Our Ref: TR010054

Date: 28 February 2020

Application by Highways England for an Order Granting Development Consent for the M54 to M6 Link Road

Advice following issue of decision to accept the application for examination

Drawing Title
**FIGUR E 13.1
 WATER BODIES
 AND THEIR ATTRIBUTES**

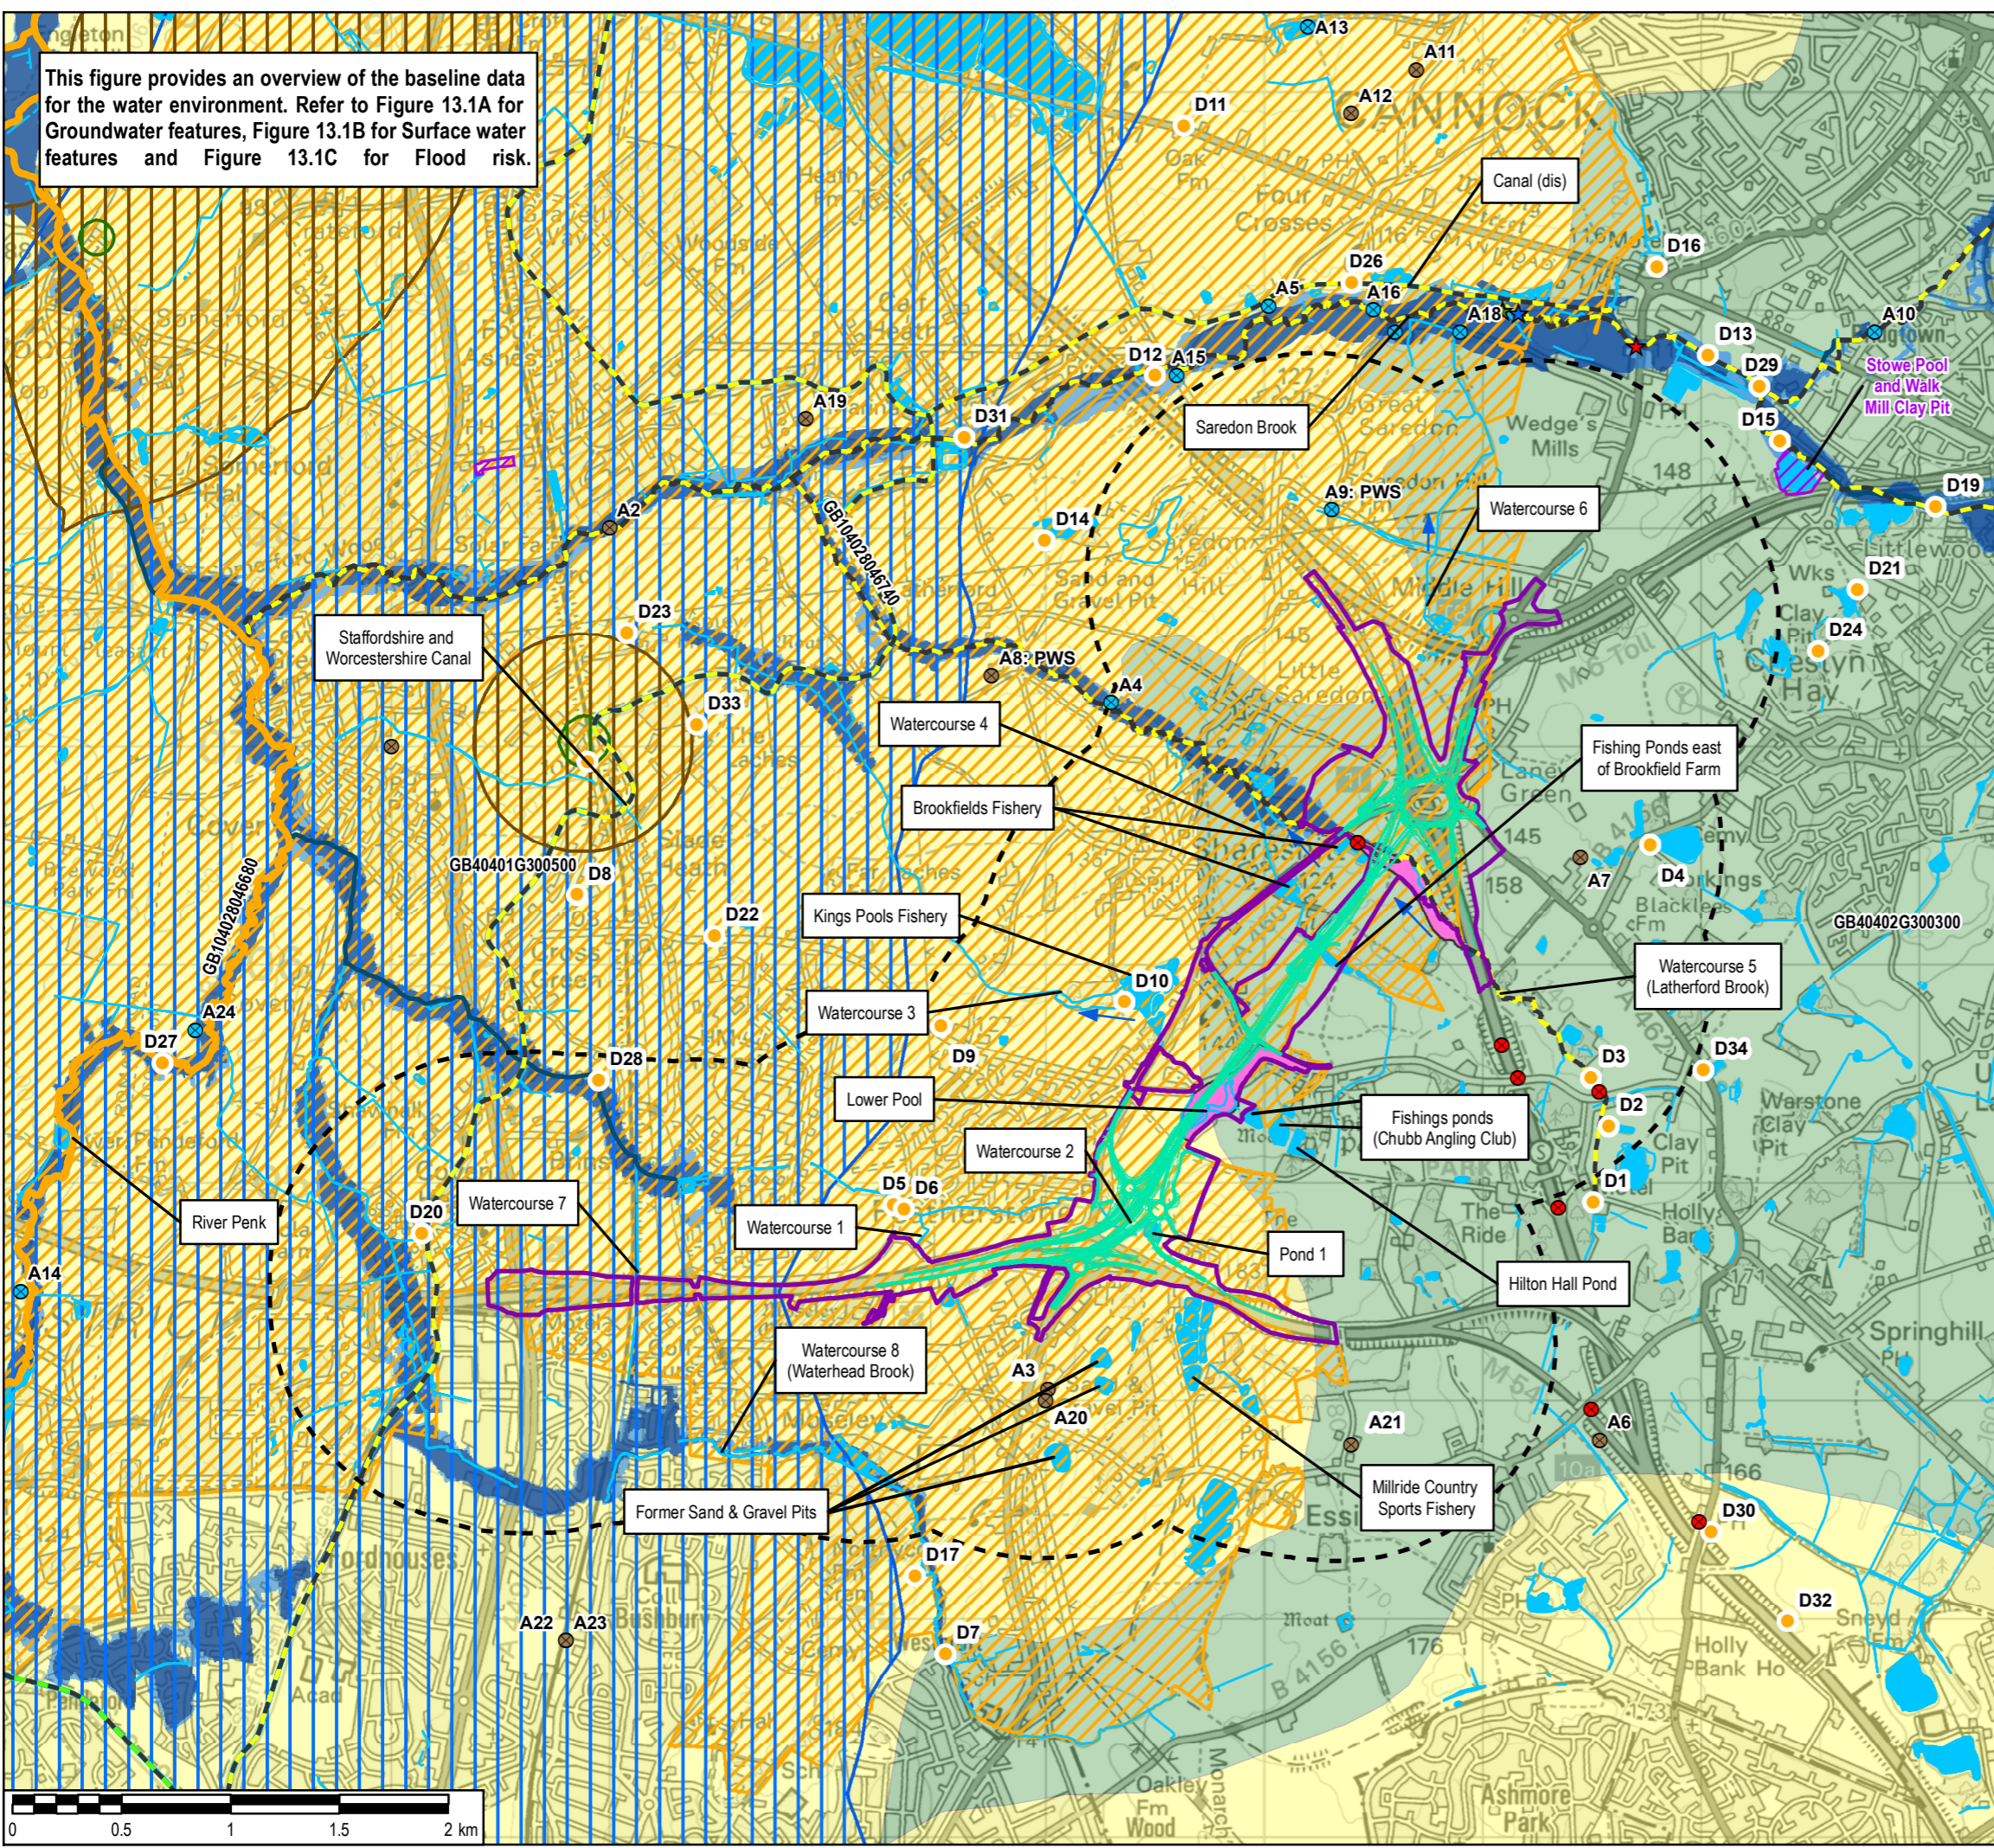
Multiple data layers have been presented in Figure 13.1 'water bodies and their attributes'. We would request that the Applicant re-submit Figure 13.1 in a clearer format; preferably with data layers presented across more than one figure no later than 10 days before the Preliminary Meeting.
